The Planning Inspectorate

Our ref: XA/2024/100232/01-L01

A46 Newark Bypass – Development Consent Order Application

Deadline 5 (04 February 2025)

**Figure 3-4 Location of interface between Scheme and Newark roundabout embankment**

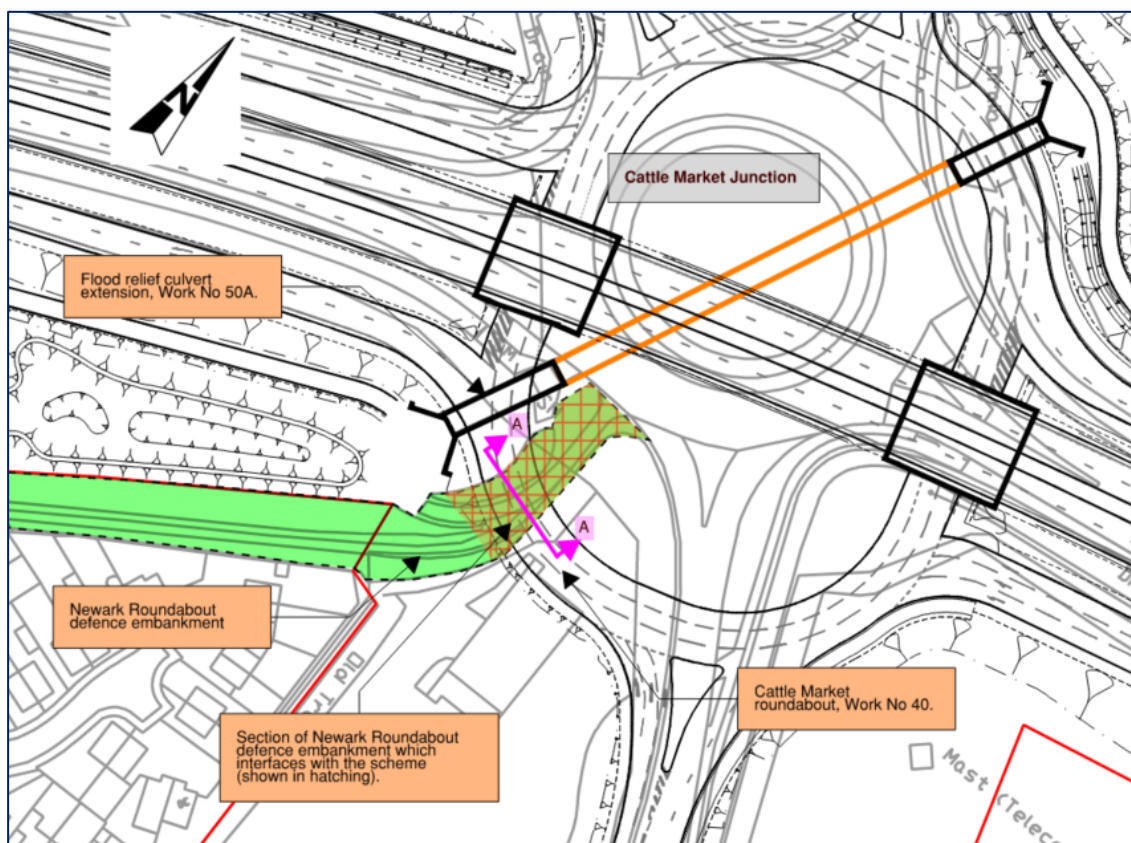
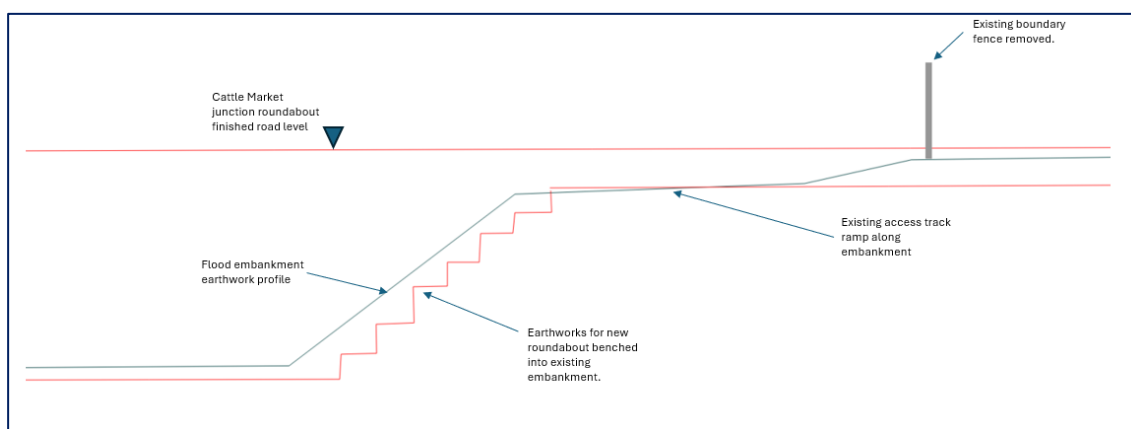
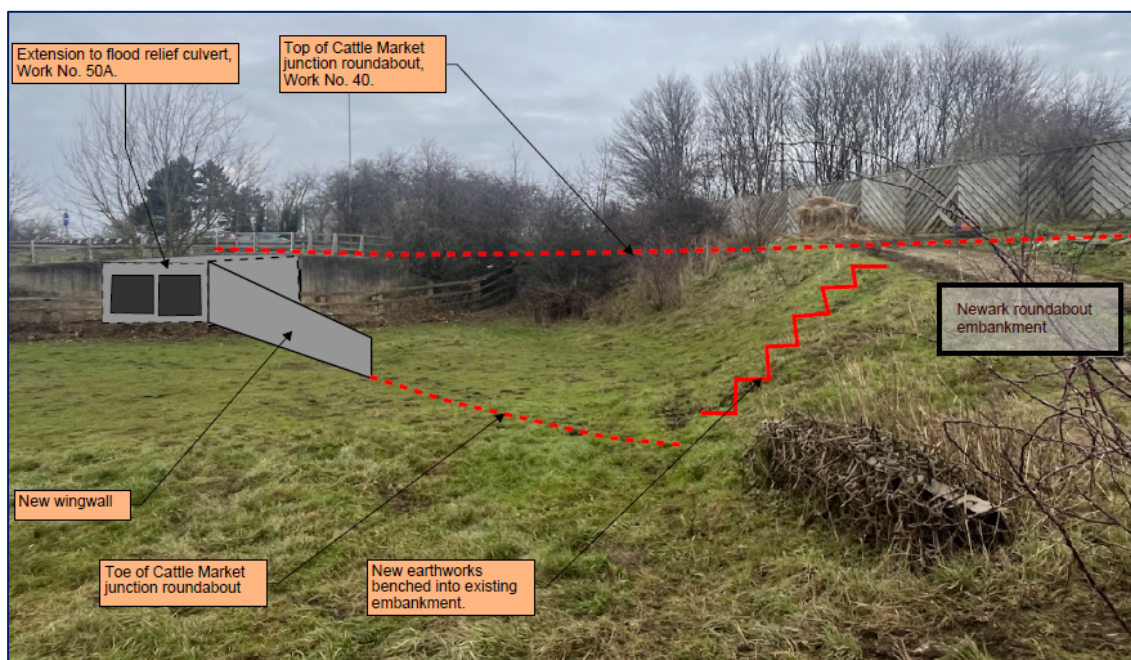
While the issue has been briefly covering in a meeting we had with the Applicant on 27 January 2025, we have not yet received sufficient detail (cross-sections, plans) or evidence that the Scheme will not have an adverse impact on the defences.
